Re: Structural Observation — 62 Angel Oak Drive, Bunnlevel, NC 28323

At your request, on February 3, 2022 we performed a review of the structural plan proposed by *Tarheel Basement Systems* for the foundation stabilization work at the Bunnlevel residence noted above. The structure is a conventionally framed, detached, single family residence with raised first floor framing over a pier/girder foundation system with perimeter masonry foundation walls (*see picture 1*).

*Repair schematic*

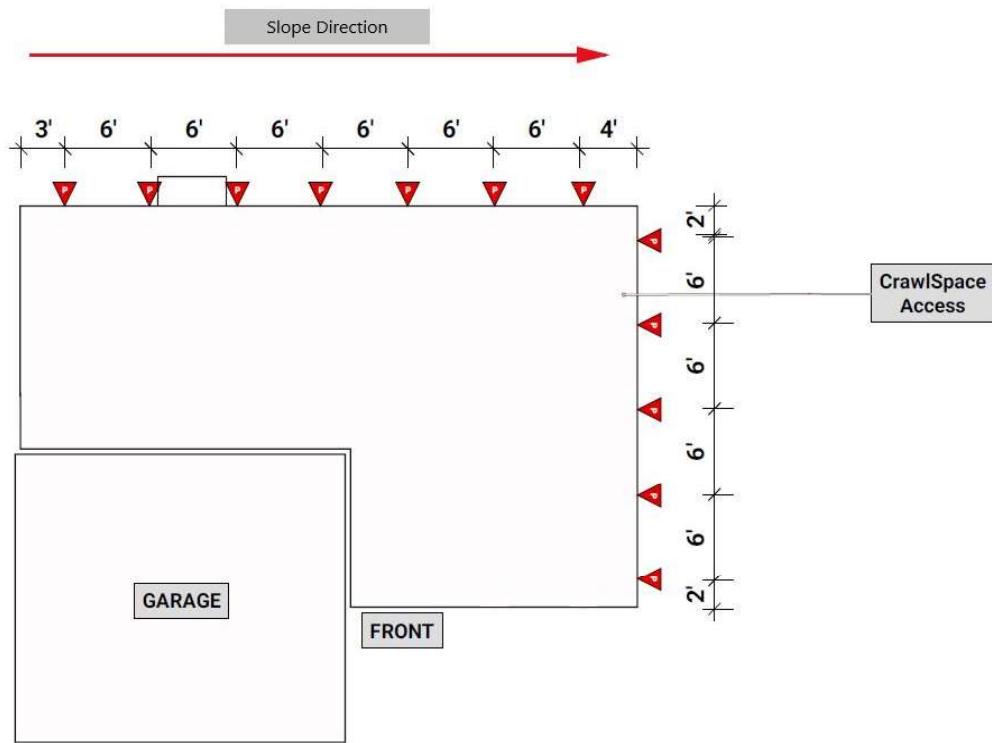
- To prevent future movement of the floor system, joists and the rim band along the back of the home should be shimmed using tight fit shim material to the tops of the knee wall top plates.
- To prevent future settlement of the back and right portions of the home, the proposed series of (12) galvanized steel helical piers or push piers may be installed.
 - Helical piers should be installed to a torque capable of developing 20 kips of axial load, or to refusal. Push piers should be driven until engagement of the structure with lift indicating adequate depth/frictional resistance along the shafts of the piers
 - The contractor should locate and avoid utilities prior to work

- Avoid installing piers under windows and doors
- Install piers at approximately 6' on center and at the approximate locations shown in the attached repair schematic.
